City of Albuquerque Stormwater Construction Site Inspection Report

General Information					
ESC File No.	K09E051	Project Name:	Titan (Spec) 150K		
NPDES Id. No.	NMR1004R6	Location:	330 94th St		
5/24/2023	Owner	Contractor			
Operator	Westpoint 40 I, LLC		Wilger Construction		
Contact name & title	Brian Paterson		Tim Lindgren		
e-mail	bpatterson@titan-development.com		tlindgren@wilger.com		
Contact Phone #	505-998-0163		505-239-0246		
COA Inspector	Doug Hughes		Start/End Time:	11AM	
Construction Phase:	Vertical				
Type of Inspection:	Regular	Storm Event	Past Storm Event >0.25"	311/Complaint	Follow Up
Weather at time of inspection?		clear		Temperature:	~ 85
Estimated date of last storm 0.25" or greater		3/16/2023

SWPPP INFORMATION SIGN (SI)

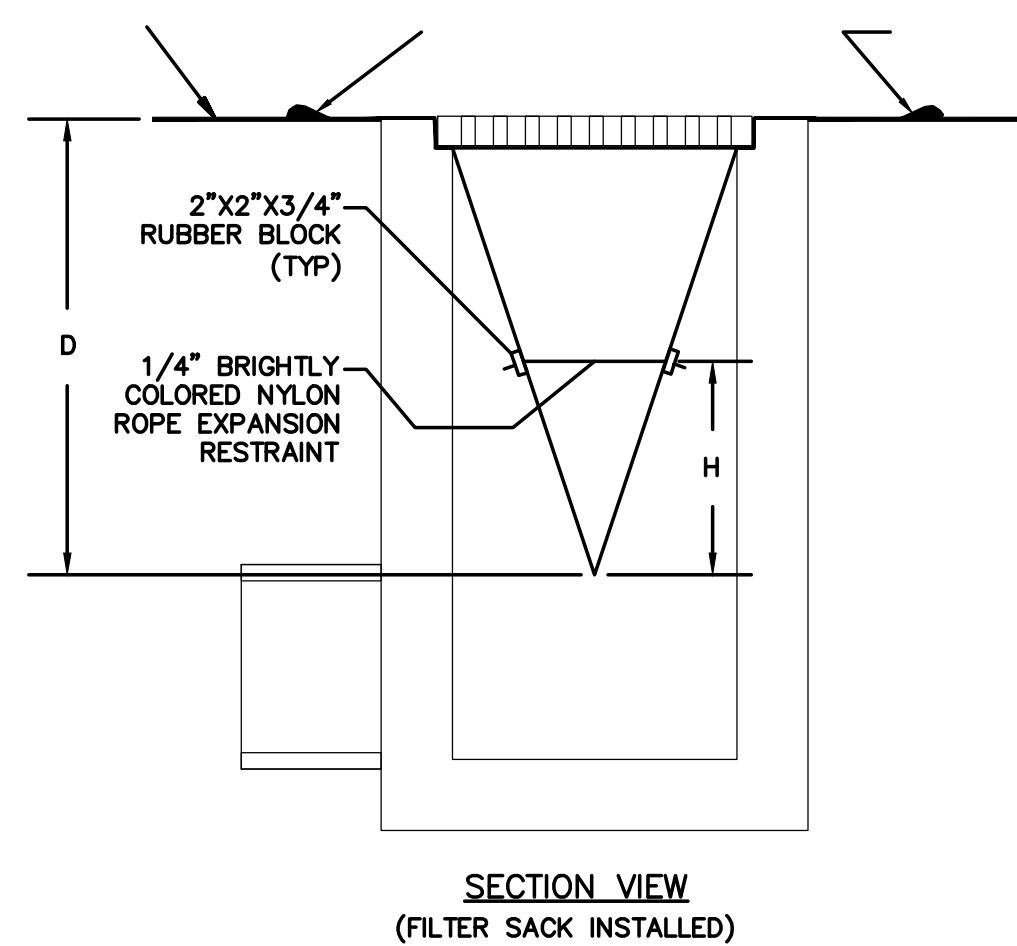
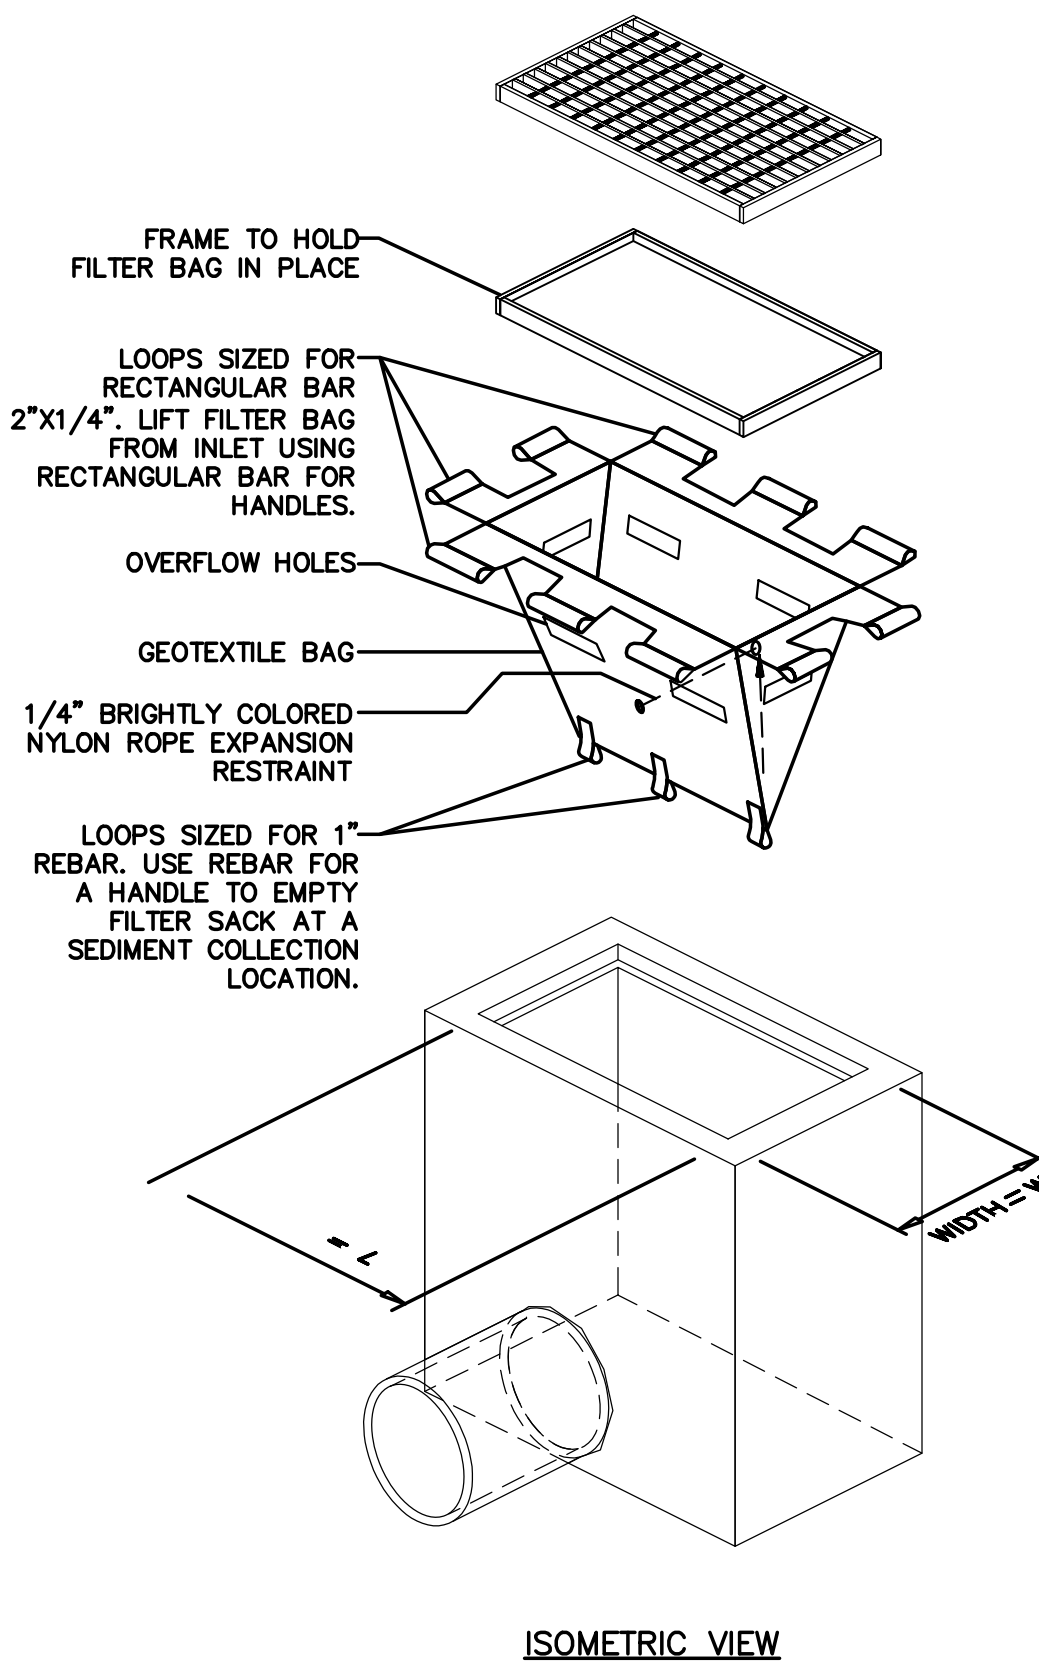
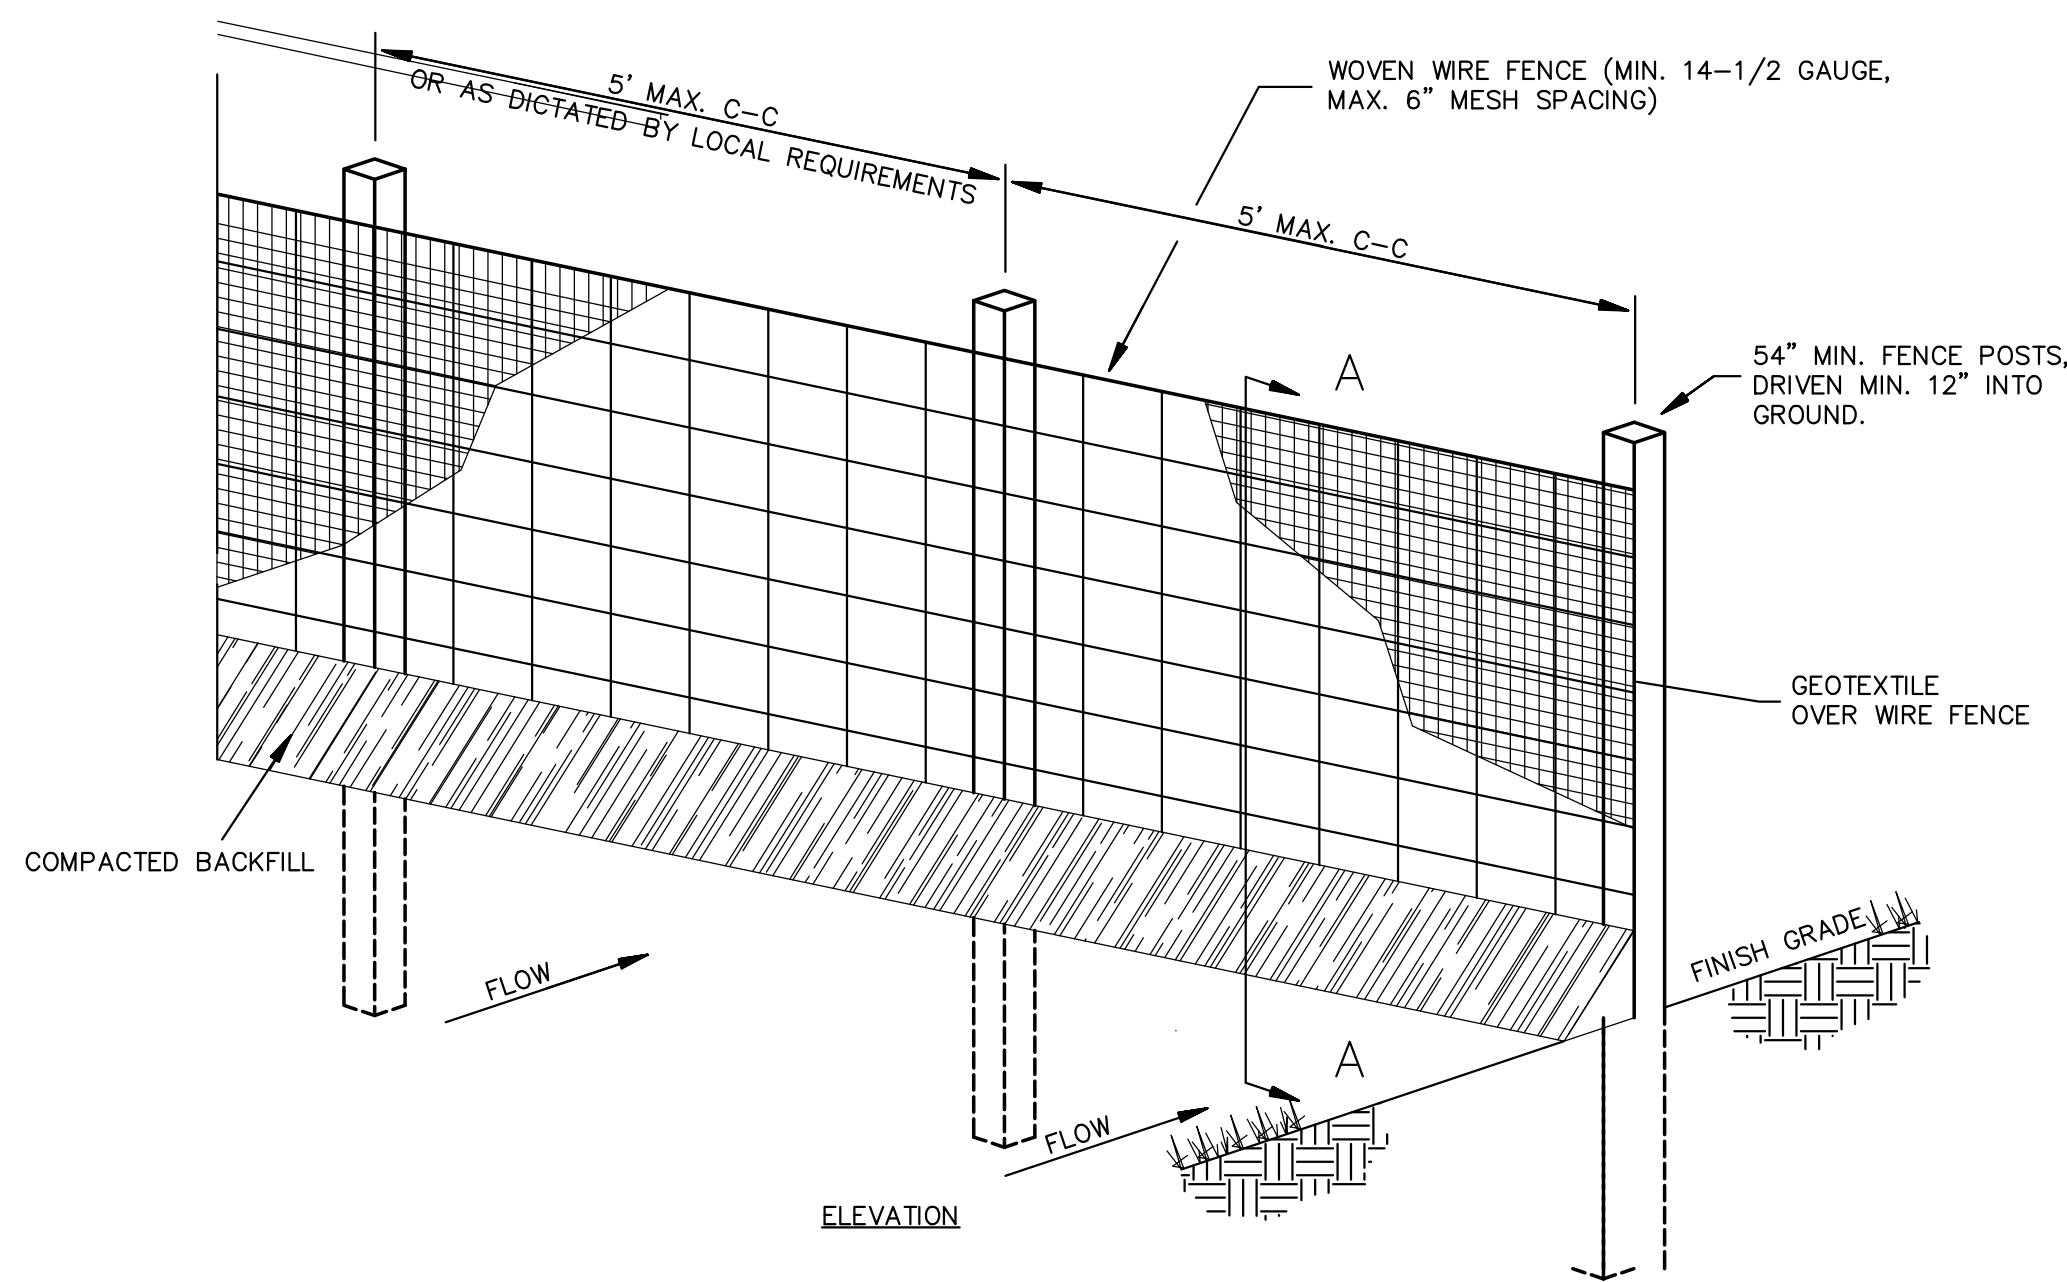
2	BMPs were missing - The silt fence shown on the SWPPP map along the south and west boundaries of the site were missing on the ground.				
3	Posting of NPDES permit coverage was too small to read. You must post a sign or other notice of your permit coverage at a safe, publicly accessible location in close proximity to the construction site. The notice must be located so it is visible from the public road that is nearest to the active part of the construction site, and it must use a font large enough to be readily viewed from a public right-of-way per CGP 1.5.
